Tel: 01903 737756
Email: planning@arun.gov.uk
www.arun.gov.uk/planning
Please ask for: Amy Anderson
Email: amy.anderson@terraquest.co.uk
Telephone: 0121 234 1390
Our Ref: M/100/25/HH
Your Ref:
Date: 10th December 2025

Application for Planning Permission for Works or Extension to a Dwelling

Development: Single storey front extension, removal of chimney, and alterations to fenestration.
Location: 9 Central Drive Middleton-On-Sea PO22 7TT

Proposed Block Plan

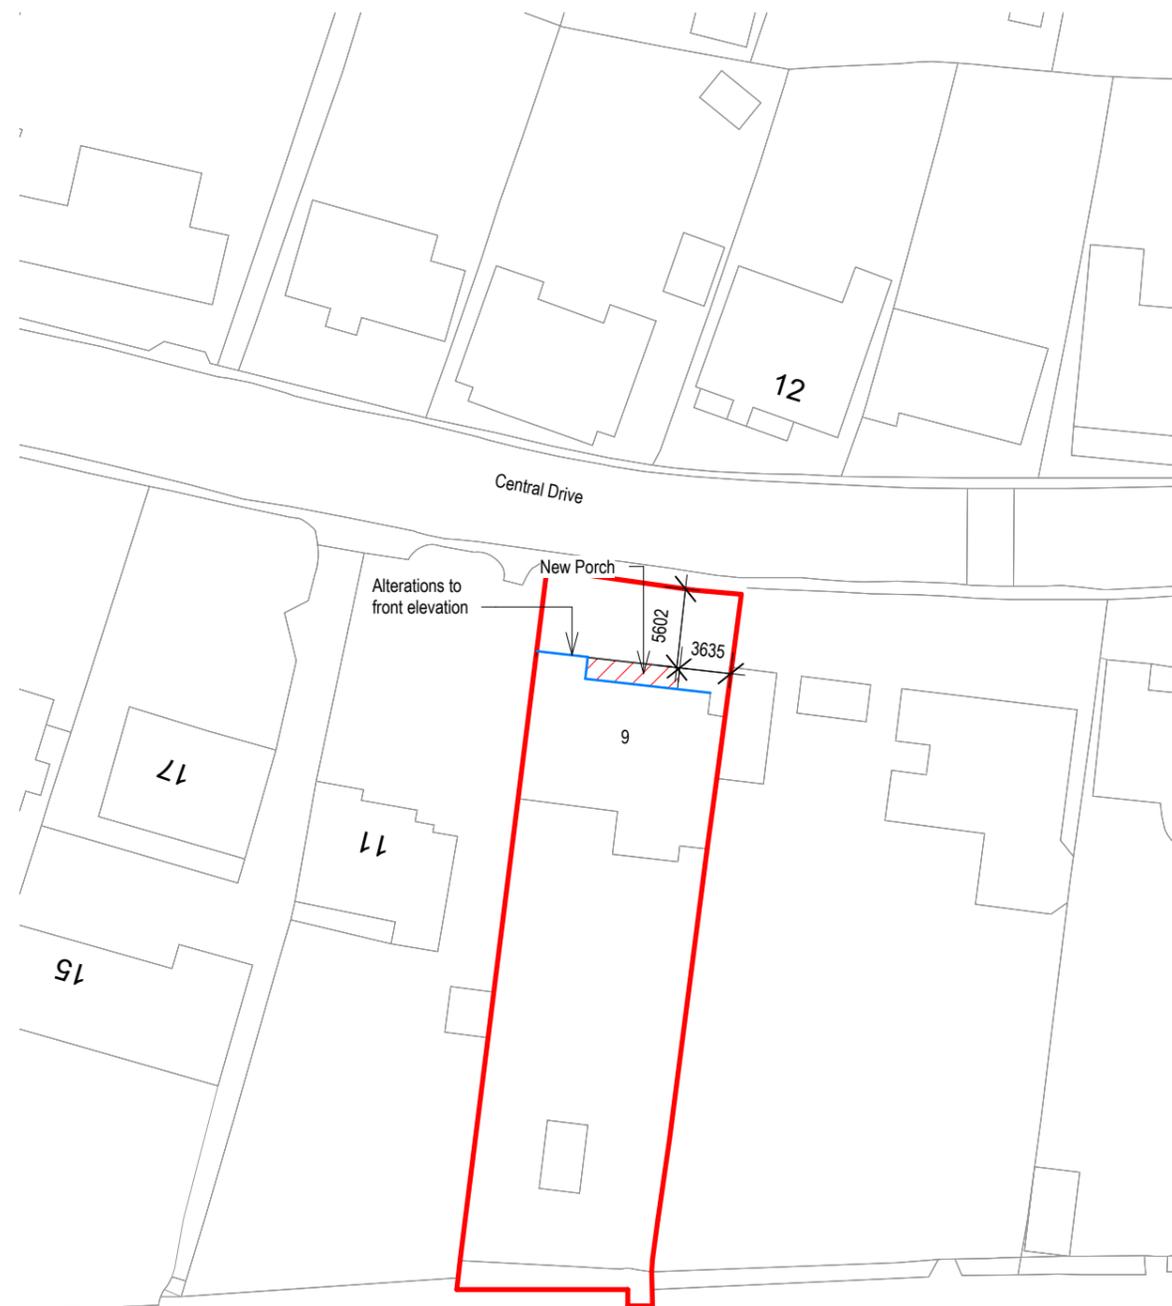
Block Plan- please annotate the block plan with the dimensions from the proposed extension to the site boundaries.
